TR010065 – A46 Newark Bypass Project

Progress on the Statement of Common Ground between the Canal & River Trust and the Promoter

Waterway: River Trent

Statement of Common Ground with Canal and & River Trust

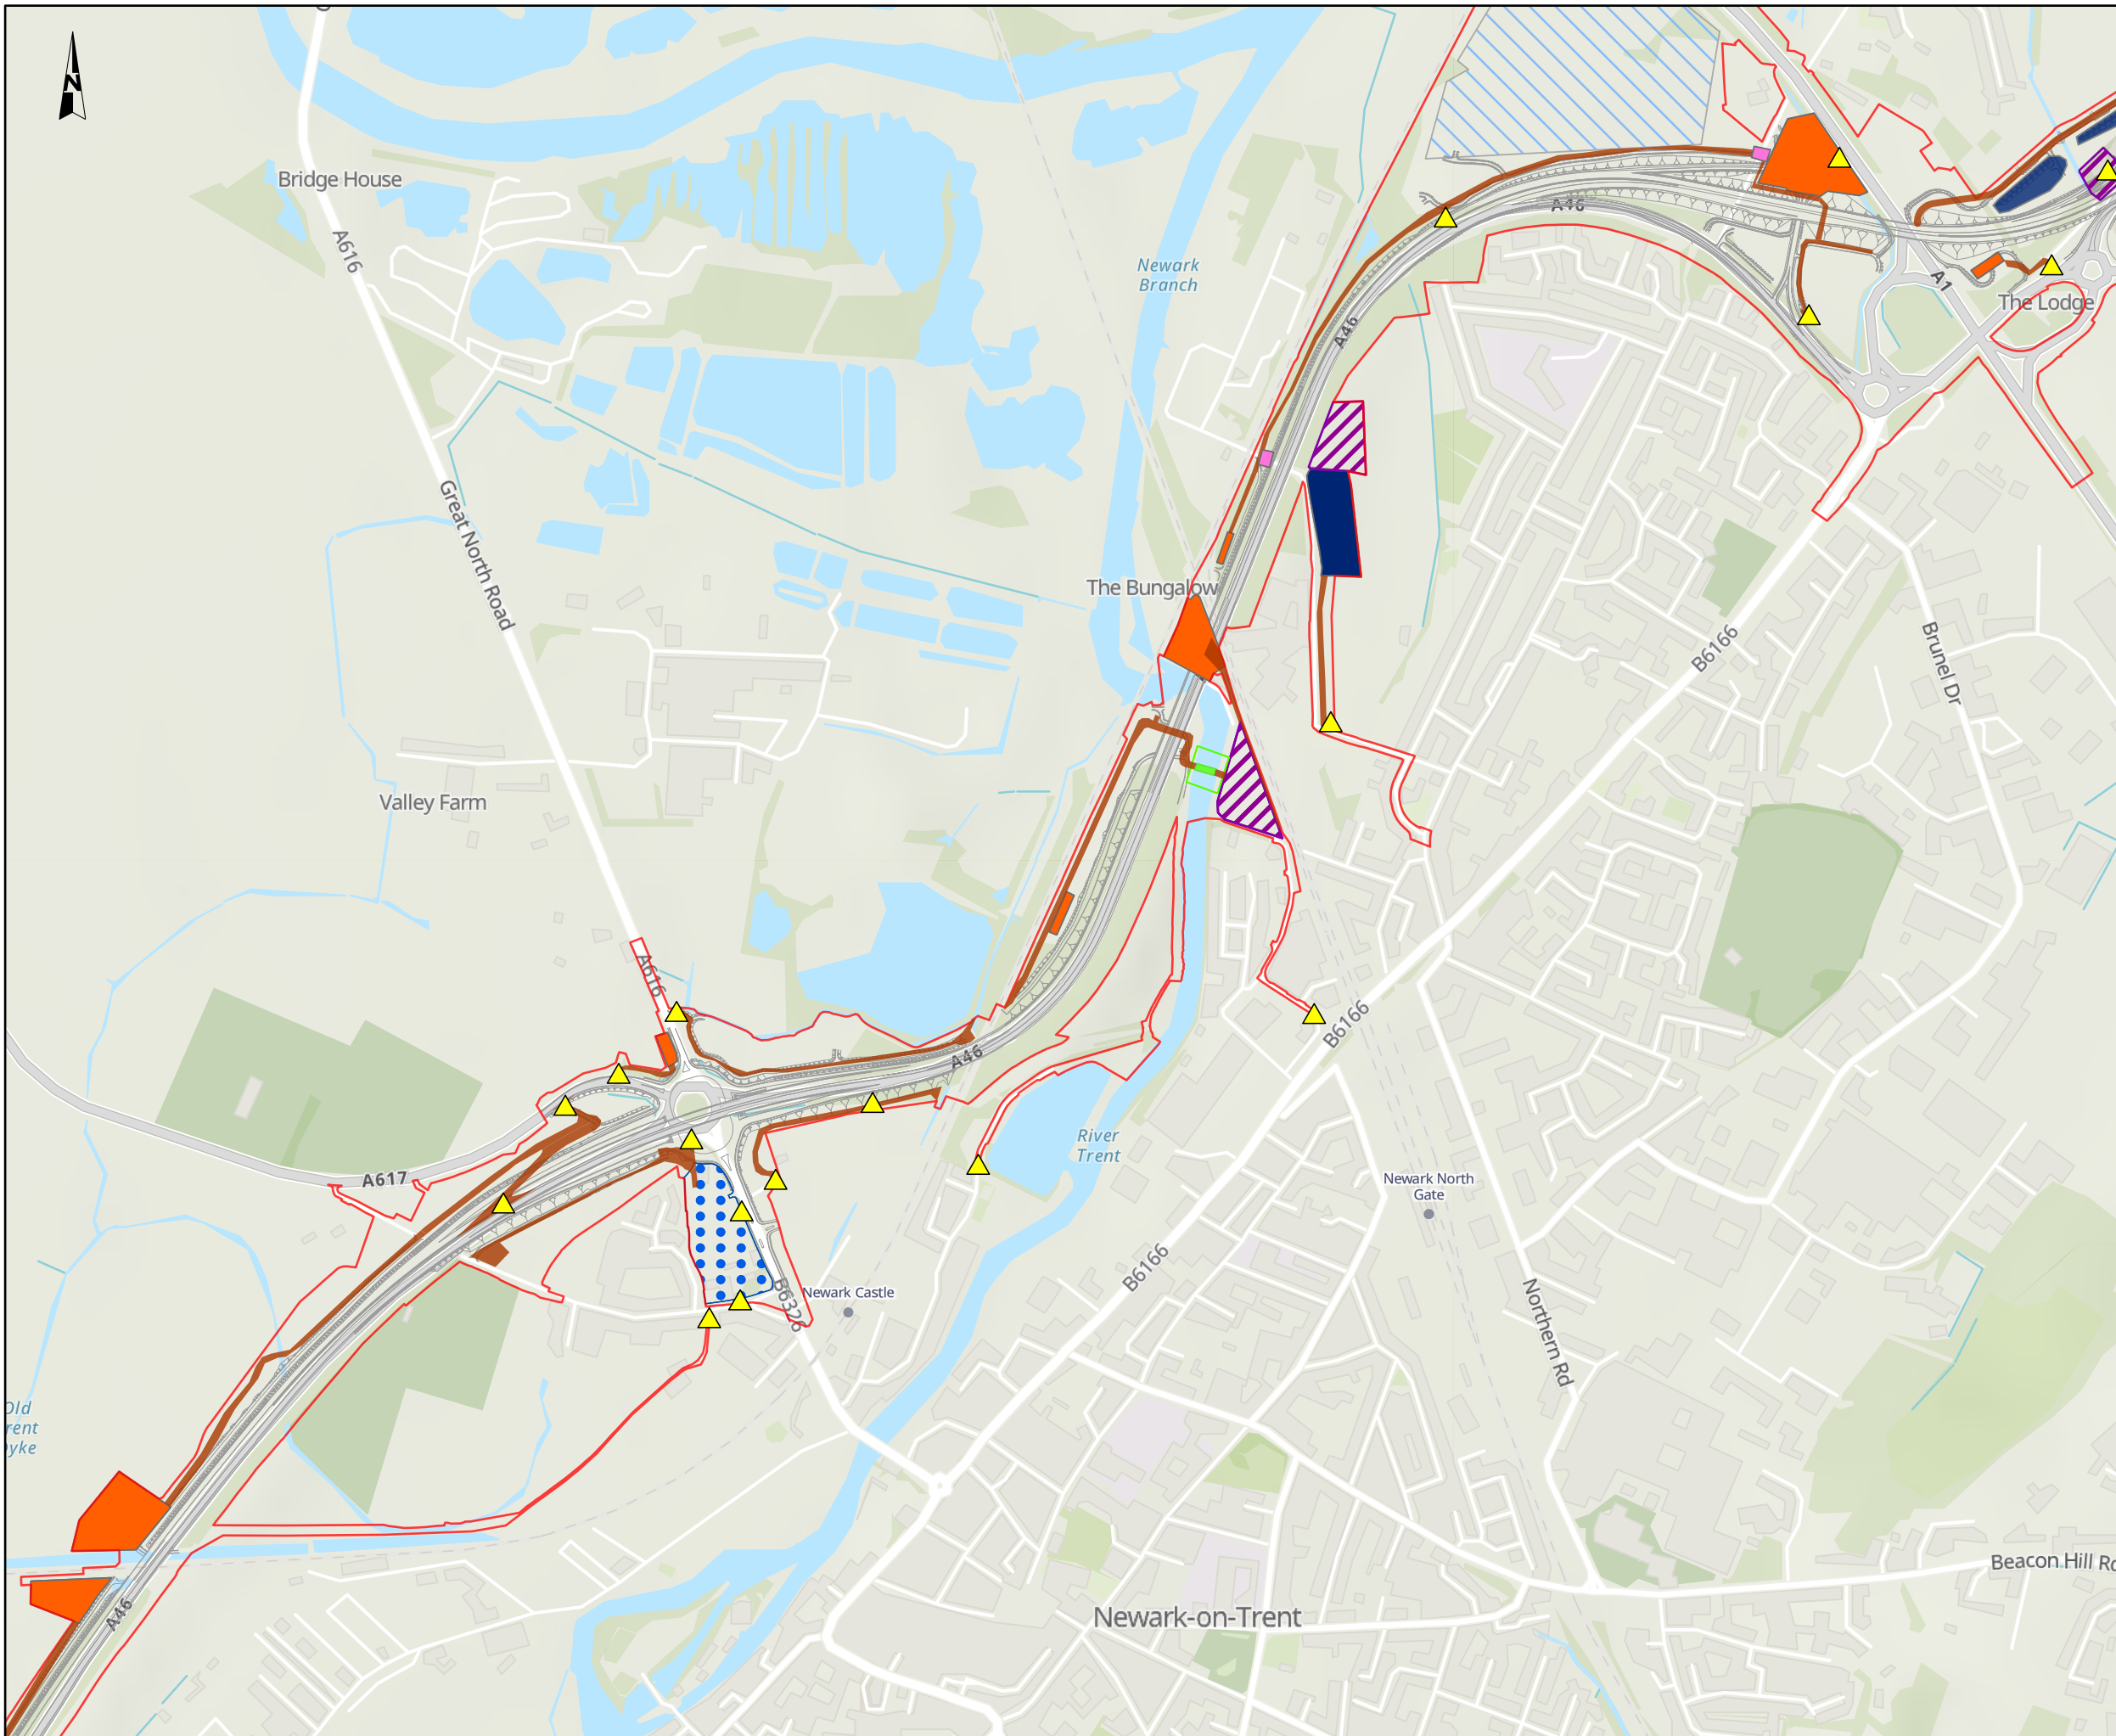
2.	Temporary Bridge Crossing of the River Trent	draft Development	A temporary bridge is proposed to provide access to the work areas.	The Applicant agrees and will provide the Approval in Principle and detailed design drawings for the temporary bridge to the Canal and River Trust for their review. This will be secured through the protective provisions.	Agreed Under discussion	26/04/2024

Issue No.	Issue	Document Reference	Canal and River Trust Position	The Applicants Position	Status	Date status confirmed
		Consent Order [REP1-001]	The Trust would need to review full details of the proposed crossing to ensure that the final design will be appropriate to allow for safe boat passage below. This could be secured via Protective Provisions.
